OBJECTION

State Significant Development Application No: SSD-10300

Coffs Harbour Cultural and Civic Space

SOUTH ELEVATION

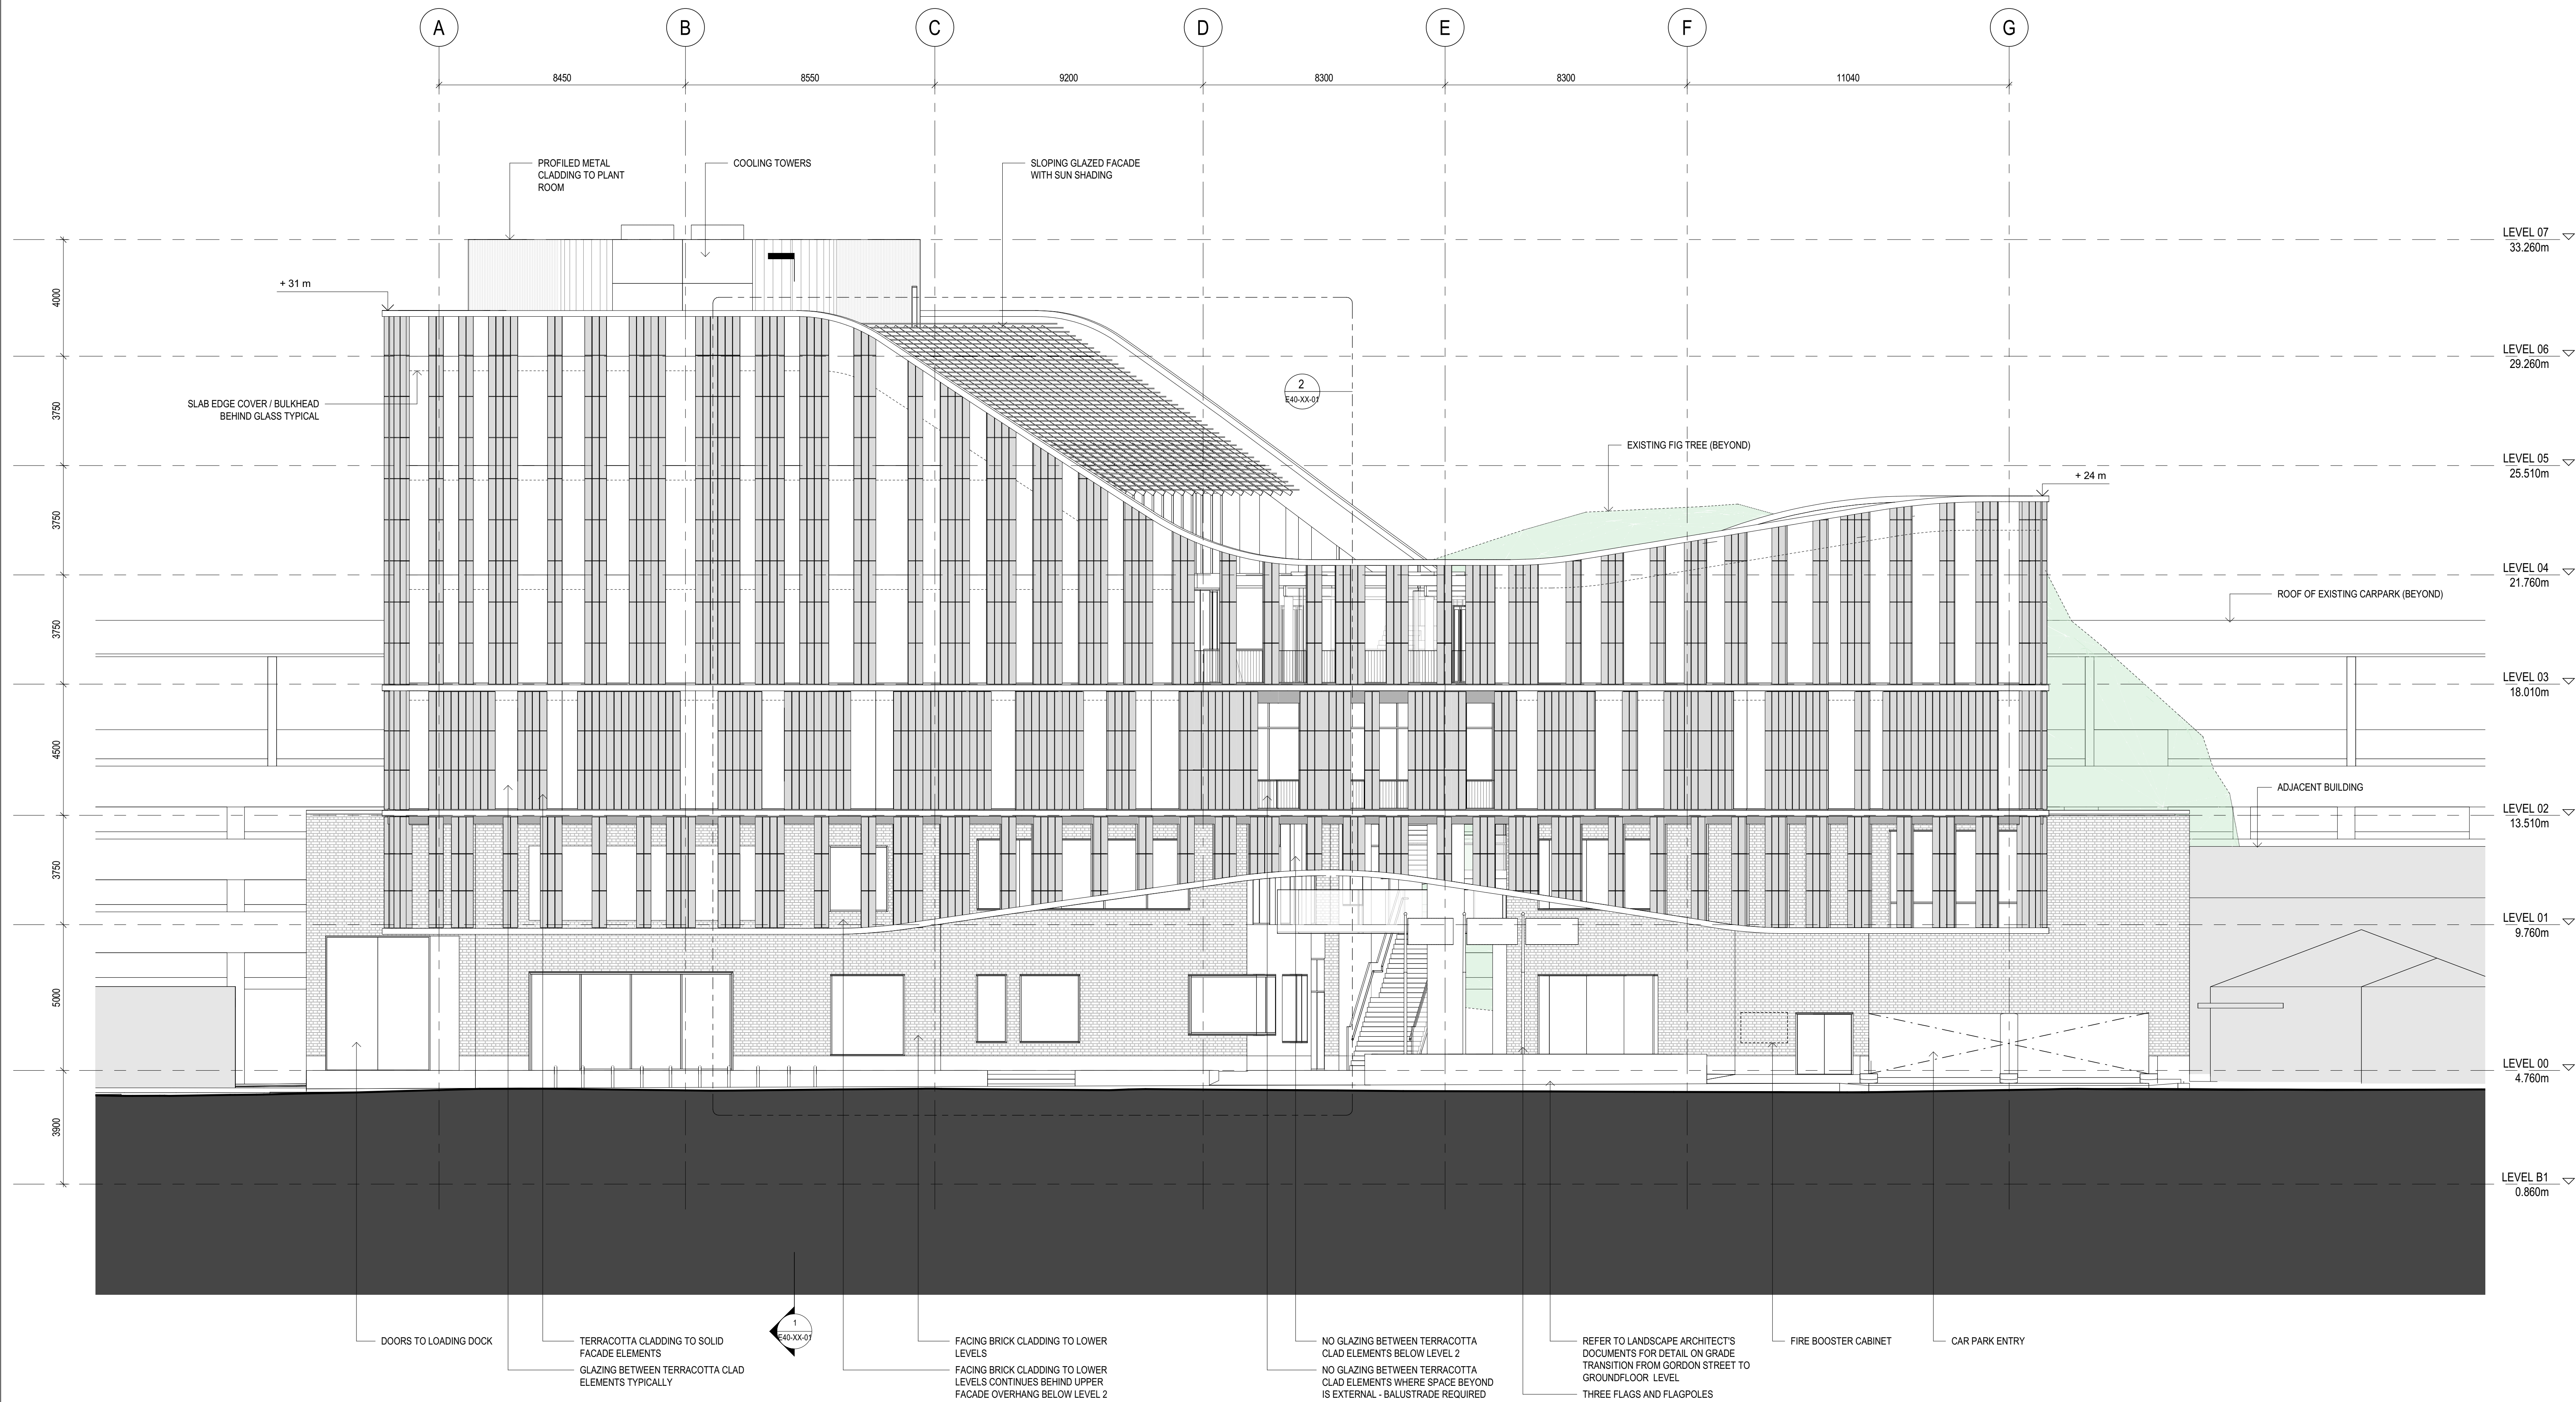
5. The proposed building is out of context in the street with no regard to scale, existing street setbacks, design and general form of adjoining buildings.

7. As a public building it fails to provide sufficient climate protection for pedestrians during storms and summer sun.
8. The building exceeds the height restriction of 28m set down in Council's own planning controls. Council's argument for variation is not satisfactorily justified and is not consistent with the objectives of the Environmental Planning and Assessment Act 1979, which requires the "the orderly and economic use and development of land". Council should not receive preferential treatment.

RIDING LANE ELEVATION

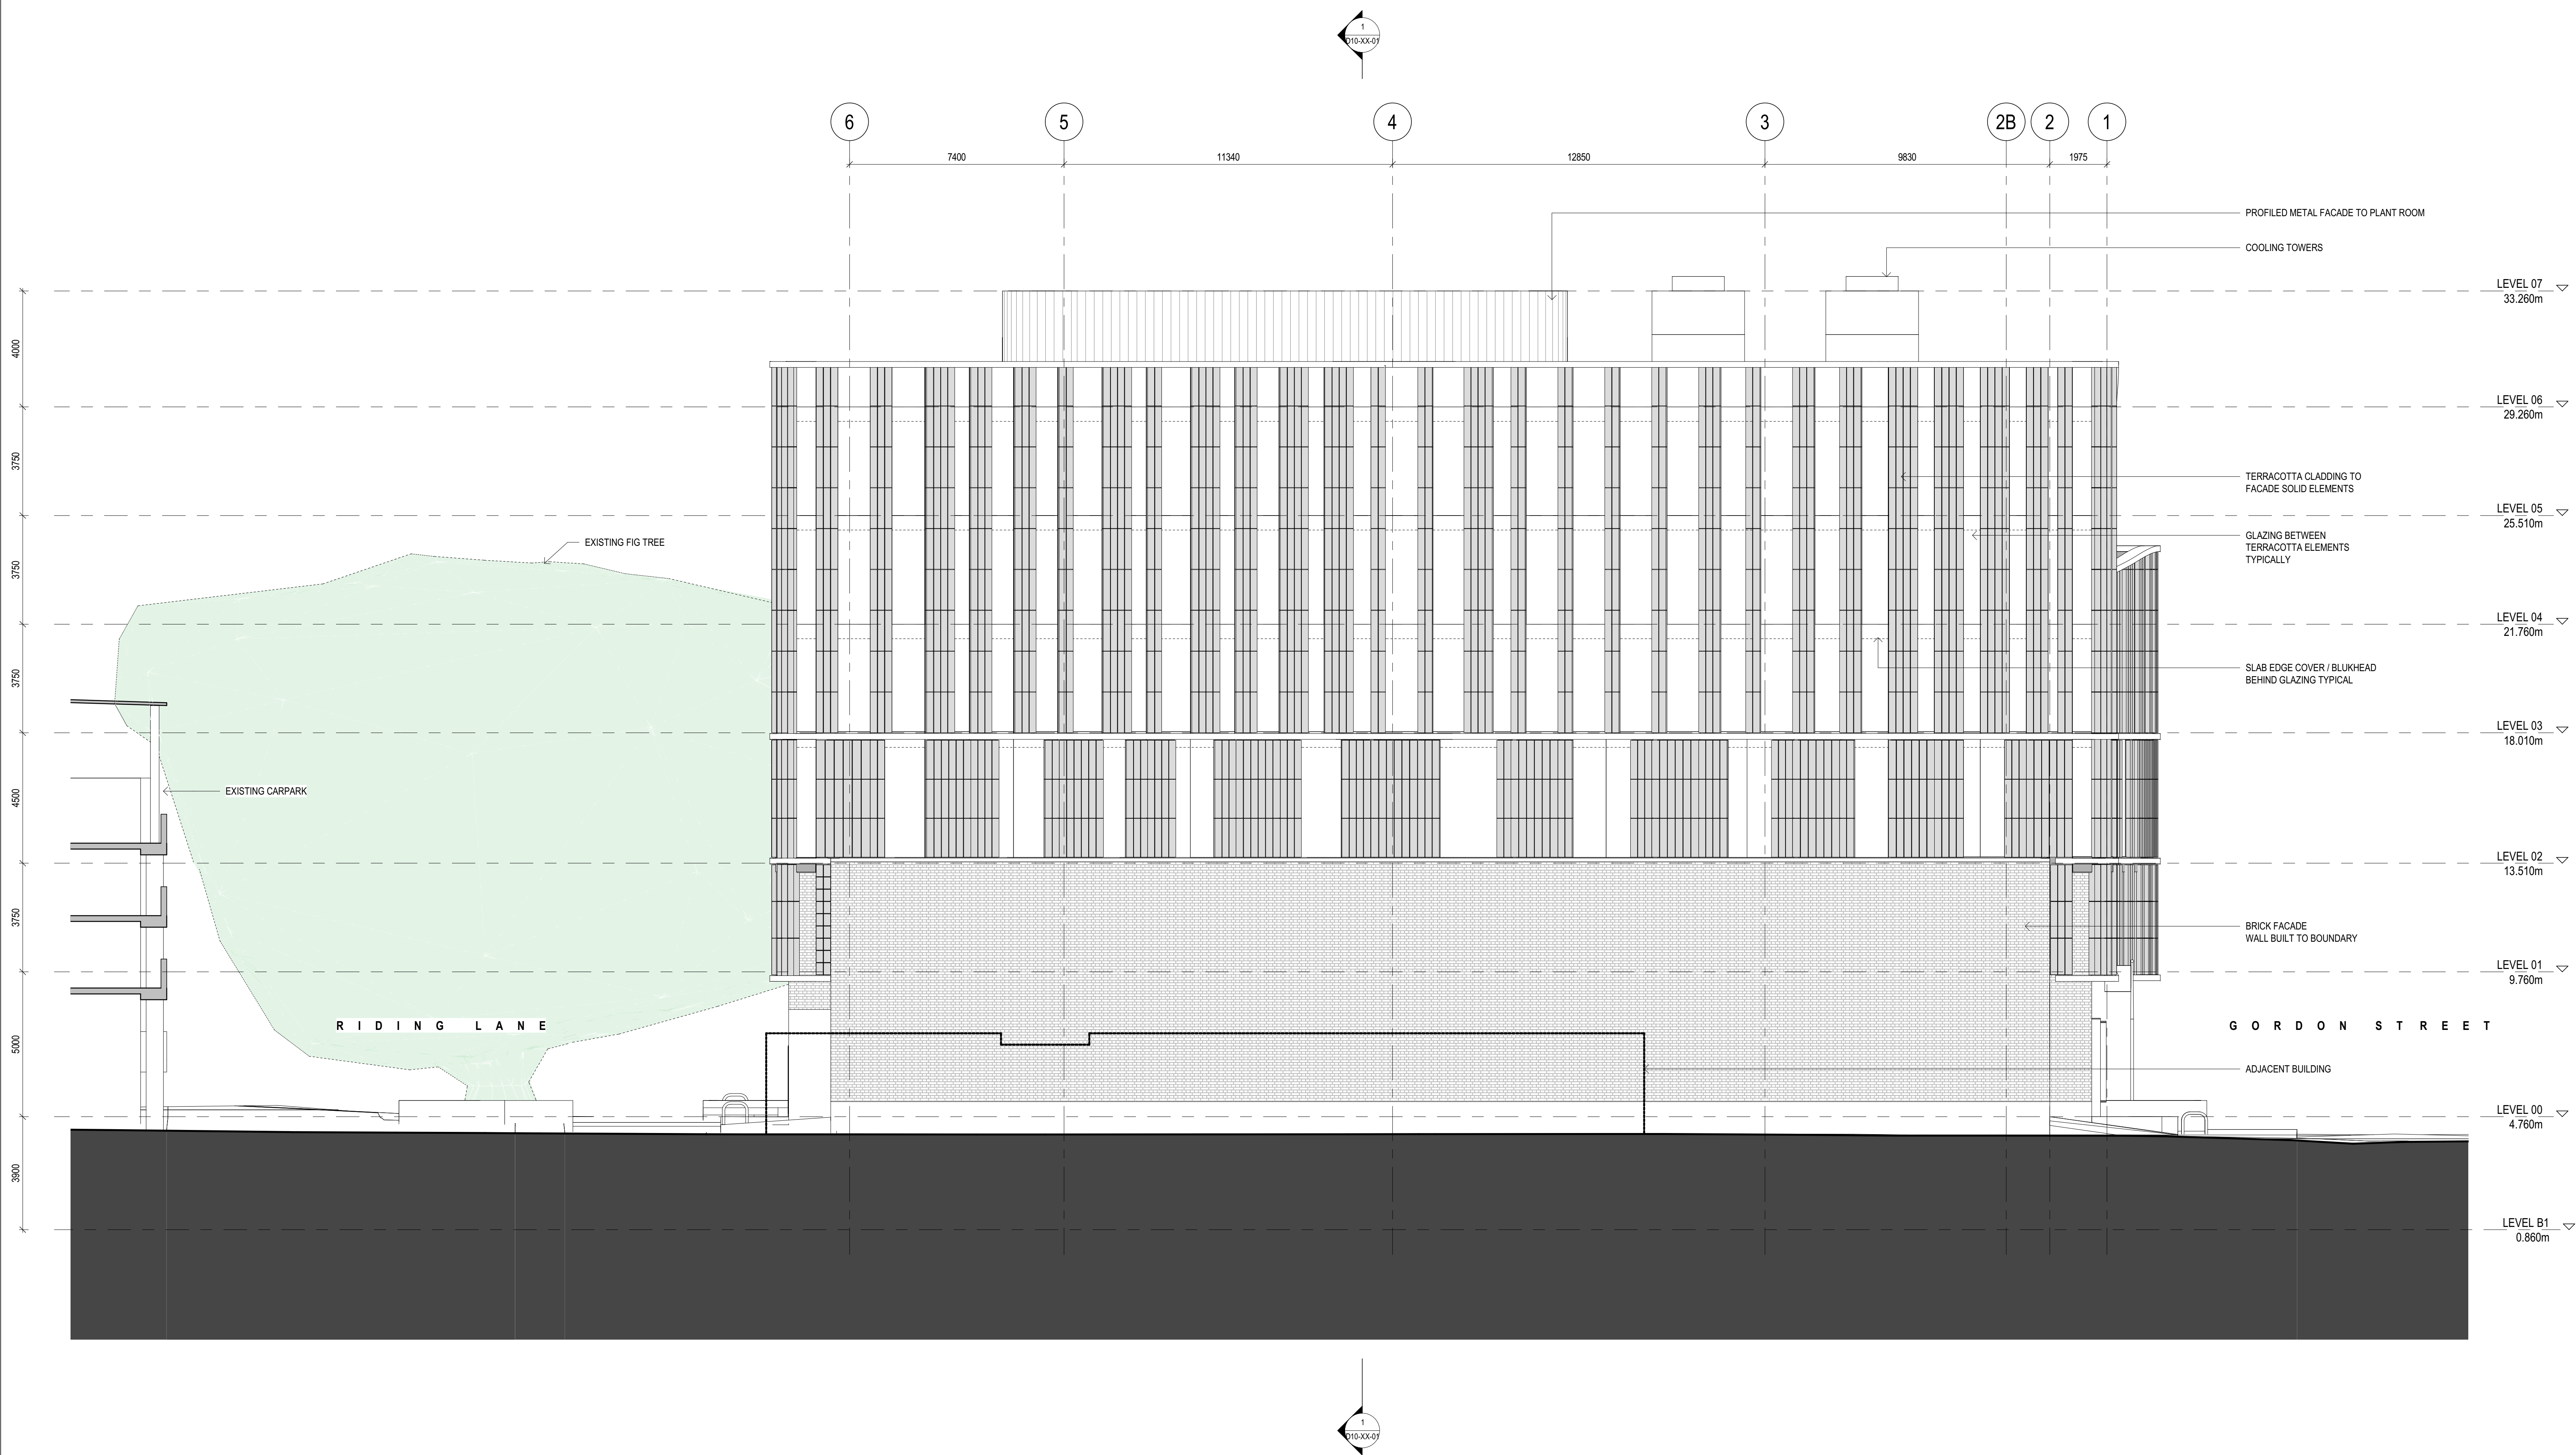
6. The proposal does not meet "safer by design" principles and guidelines, as the arcade to Riding Lane confuses boundaries and provides "hides" for criminal activity, vagrancy and prevents good surveillance.
